KINCH SUBDIVISION Construction Drawings El Paso County, Colorado

JANUARY 2022

| NO. | REVISION | BY | DATE |
|-----|---------------|-----|---------|
| 1 | EPC SUBMITTAL | JPS | 1/10/22 |

PLAN & PROFILE KINCH COURT

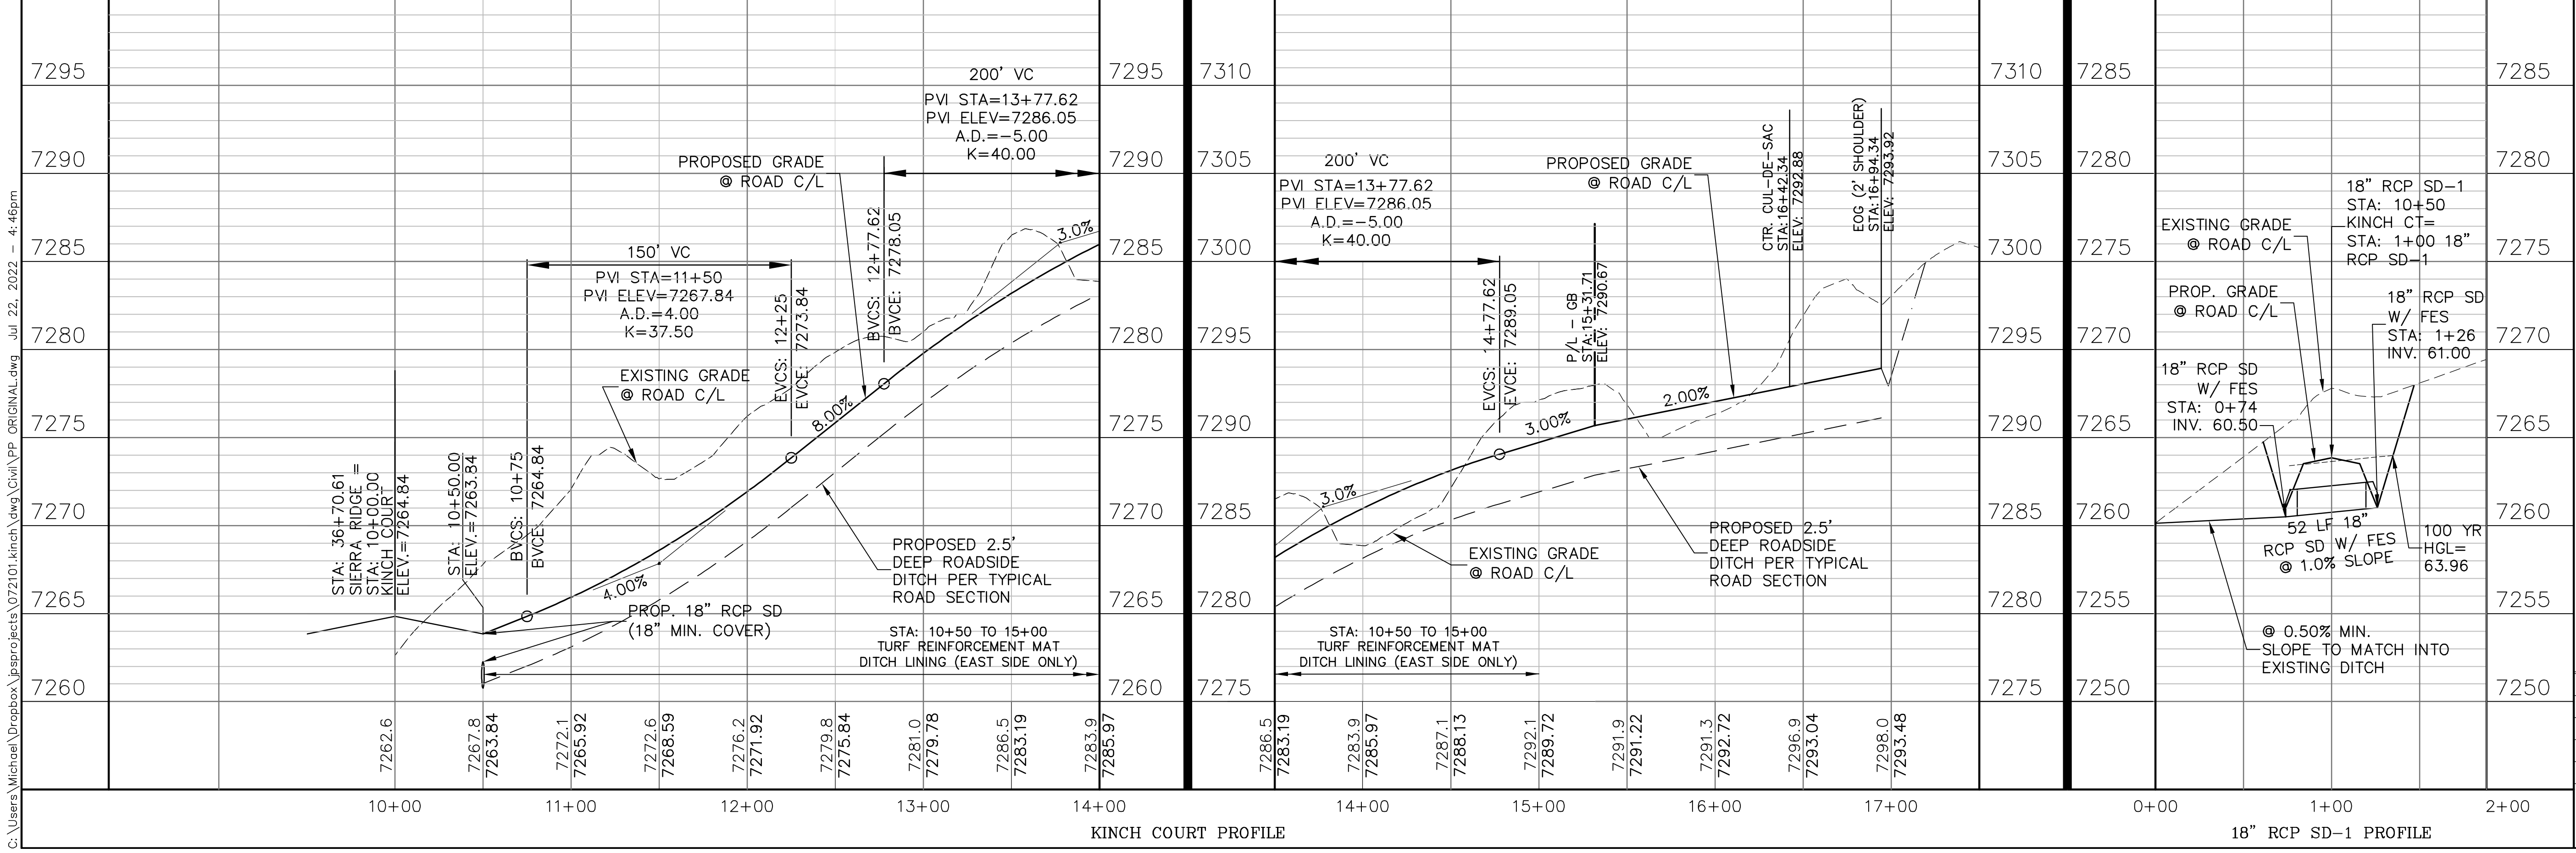
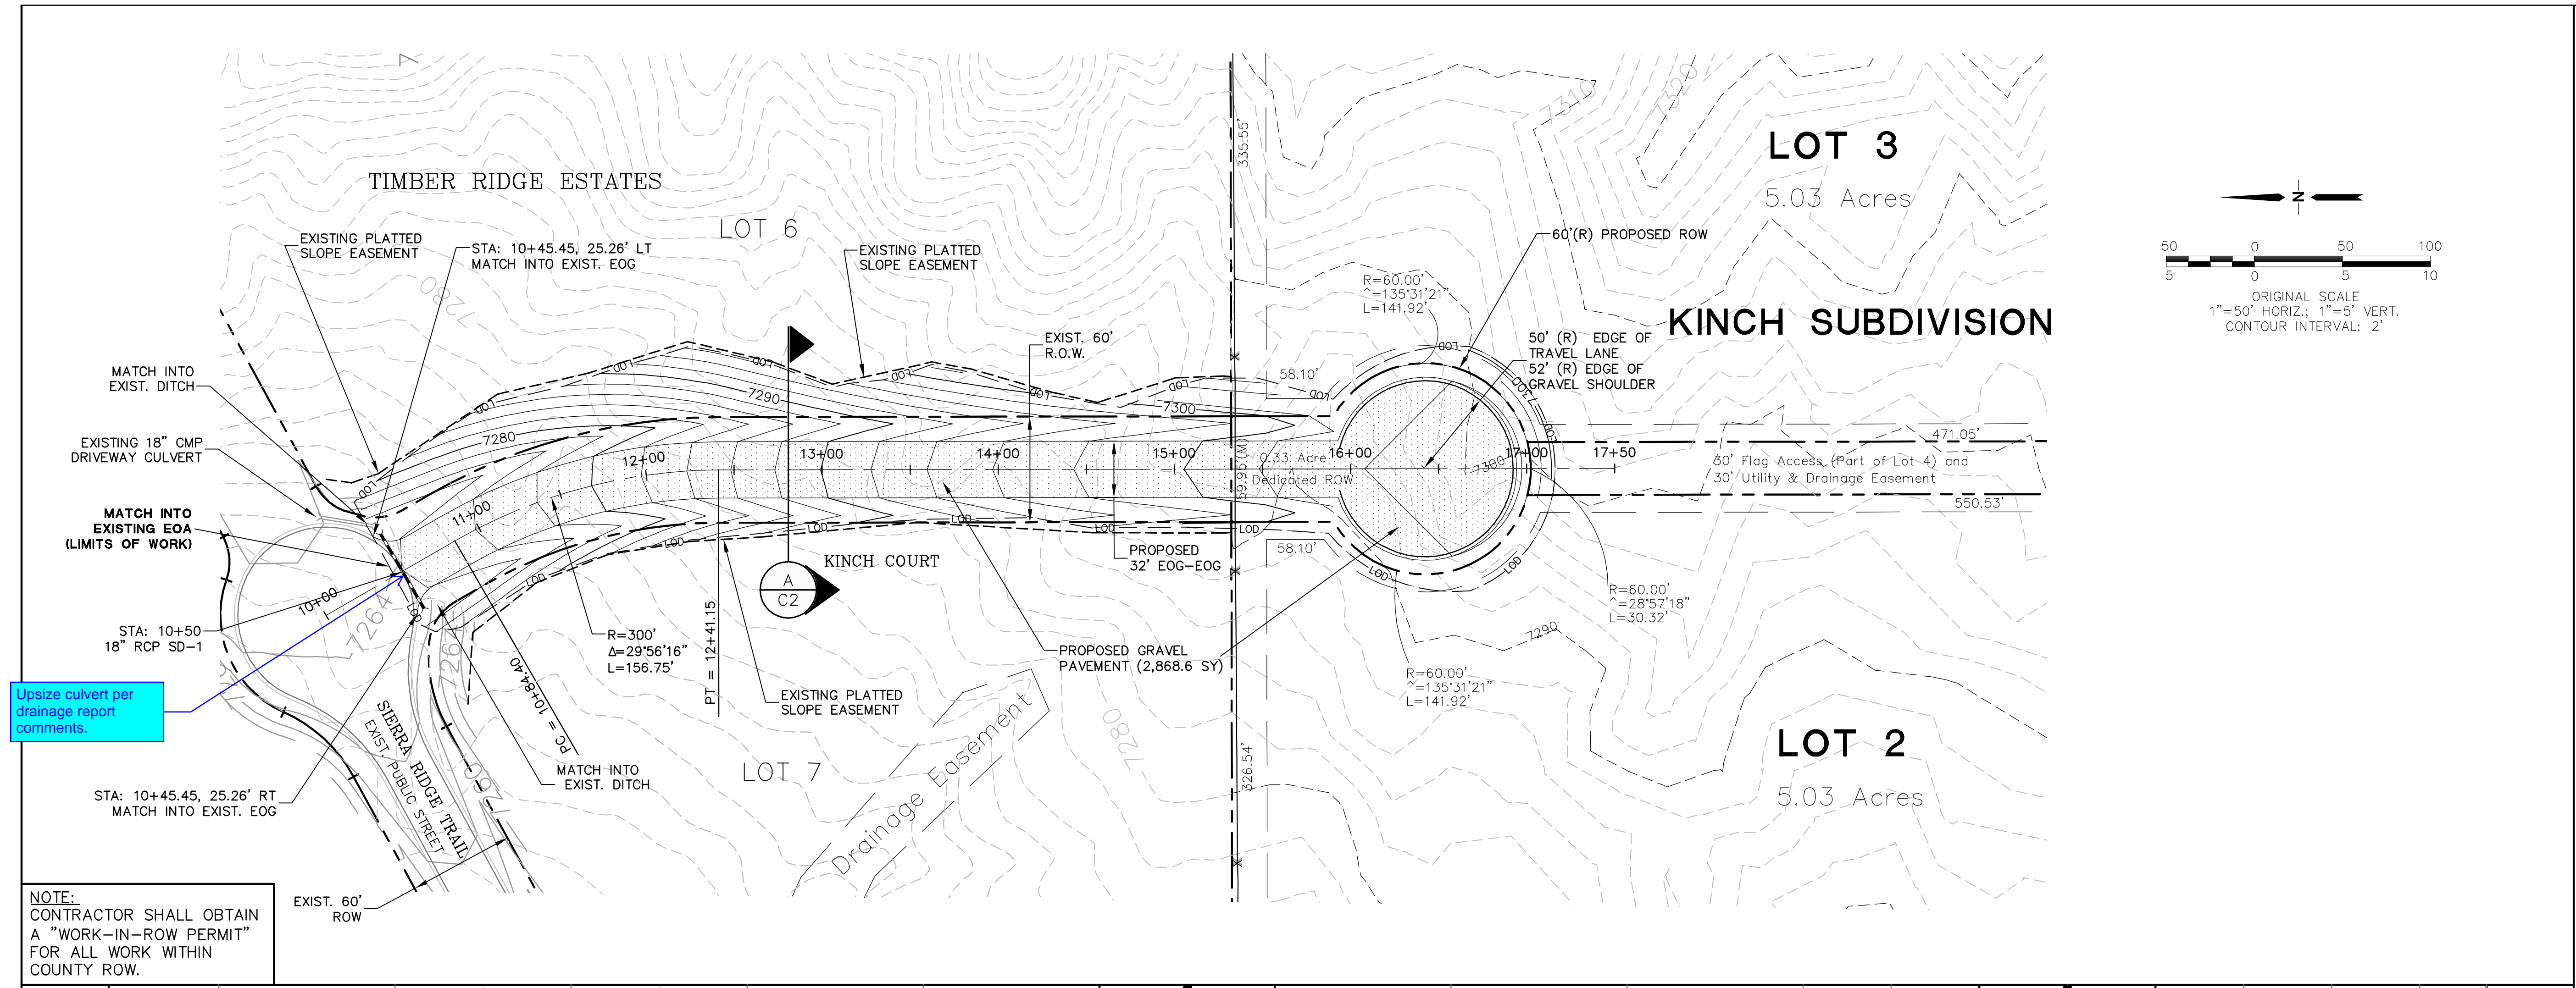
Please show the following:

- Ditch flowlines on profile, per ECM 2.5.8.C ditches shall have a minimum depth of 24 inches.
- Update plan to show entire limits of construction and disturbance. The grading and erosion control plan shows limits of construction and disturbance that extend onto the majority of Sierra Ridge Trail. If any grading is being proposed to Sierra Ridge Trail update the plan and profile to show proposed changes. Please note: Sierra Ridge Trail is County owned and maintained and a Work in the ROW permit will be required to do any work within public ROW. At the moment it is unclear what changes are proposed to Sierra Ridge Trail.
